Planning and Regulatory. G.Mansfield
PB2017/01875
Phone: 02 4974 2767

20 December 2017

MIXED USE COMMERCIAL AND RESIDENTIAL DEVELOPMENT DOMA HOLDINGS 50 HONEYSUCKLE DRIVE NEWCASTLE (SSD 8019)

Honeysuckle View Corridor - Pedestrian Site Through Link

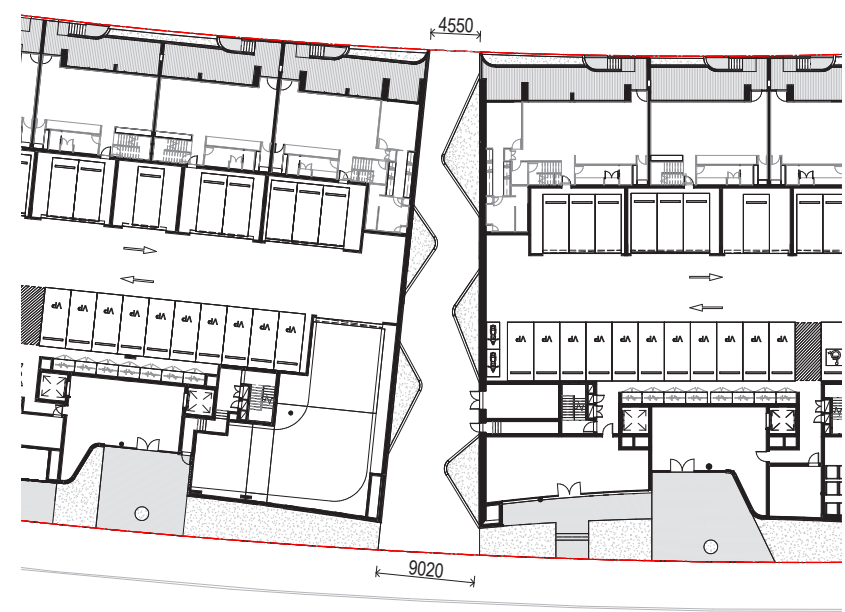
This issue has been generally been satisfactorily addressed, however no details have been provided of any proposed lighting in the pedestrian through-link - an important CPTED consideration.

An appropriate condition has been provided to ensure the general public have unimpeded access via the through-link from Worth Place Park to Honeysuckle Drive.

Balustrade Details

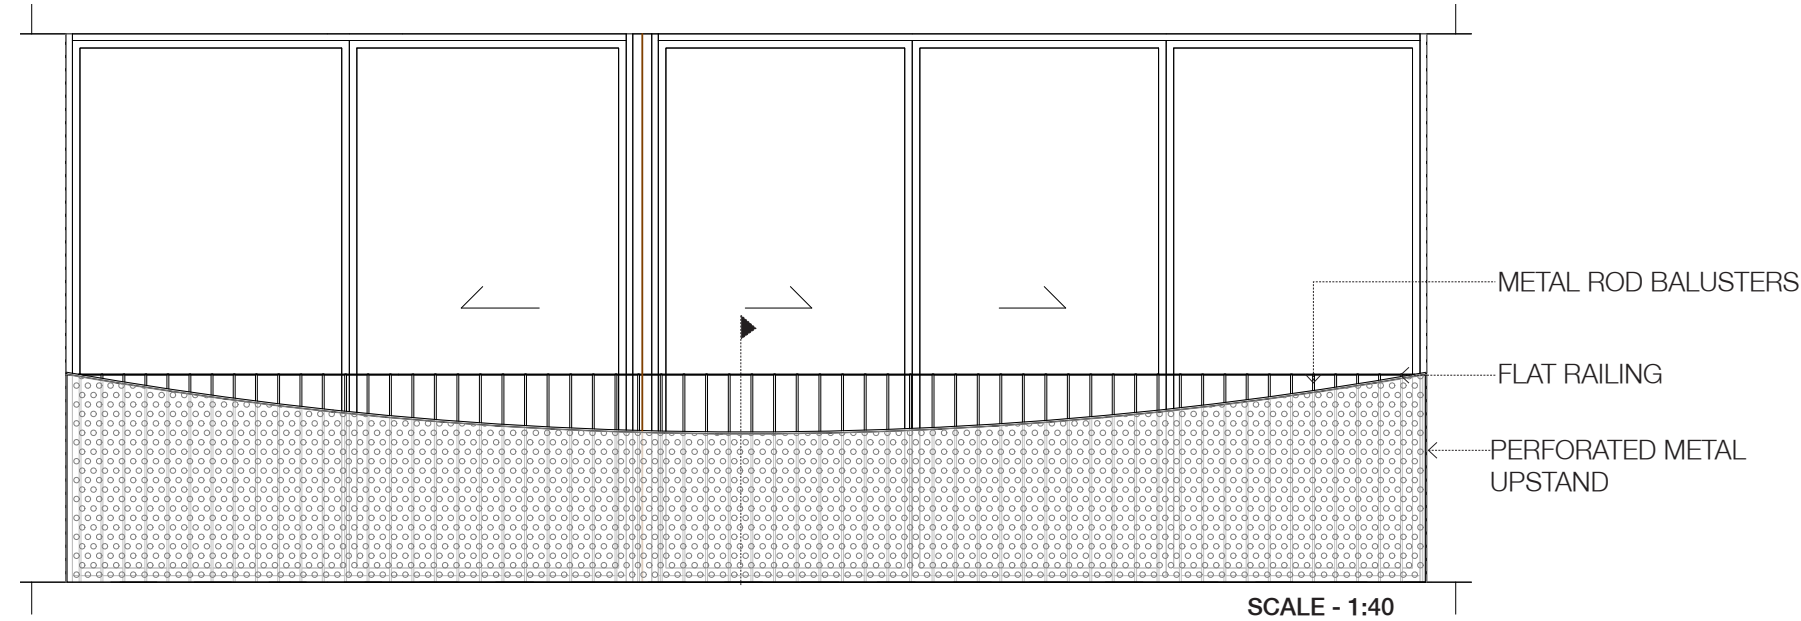
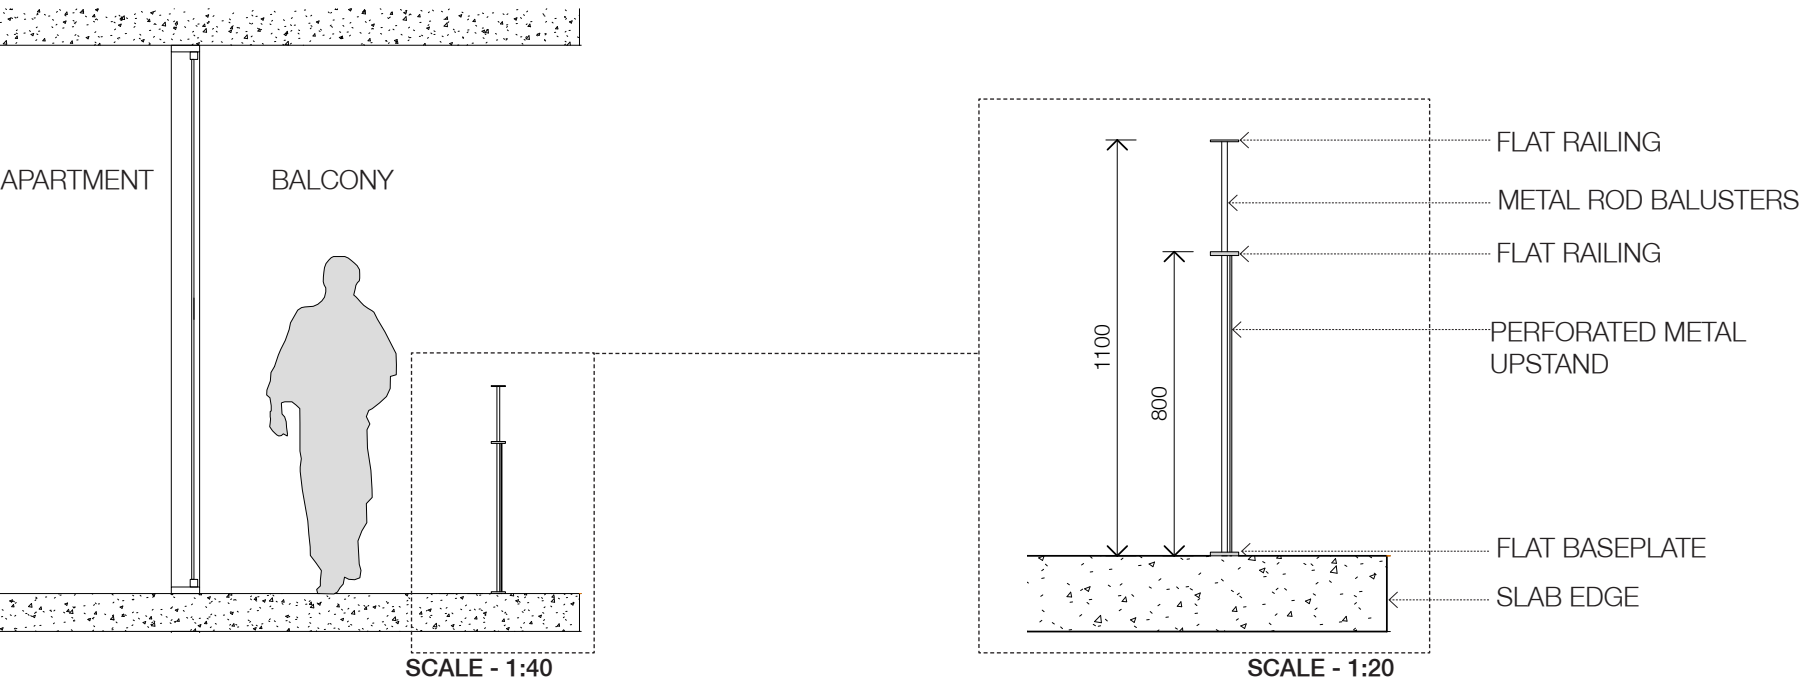
This issue has been satisfactorily addressed by the proposed amendments to the design and appearance of the balustrades.
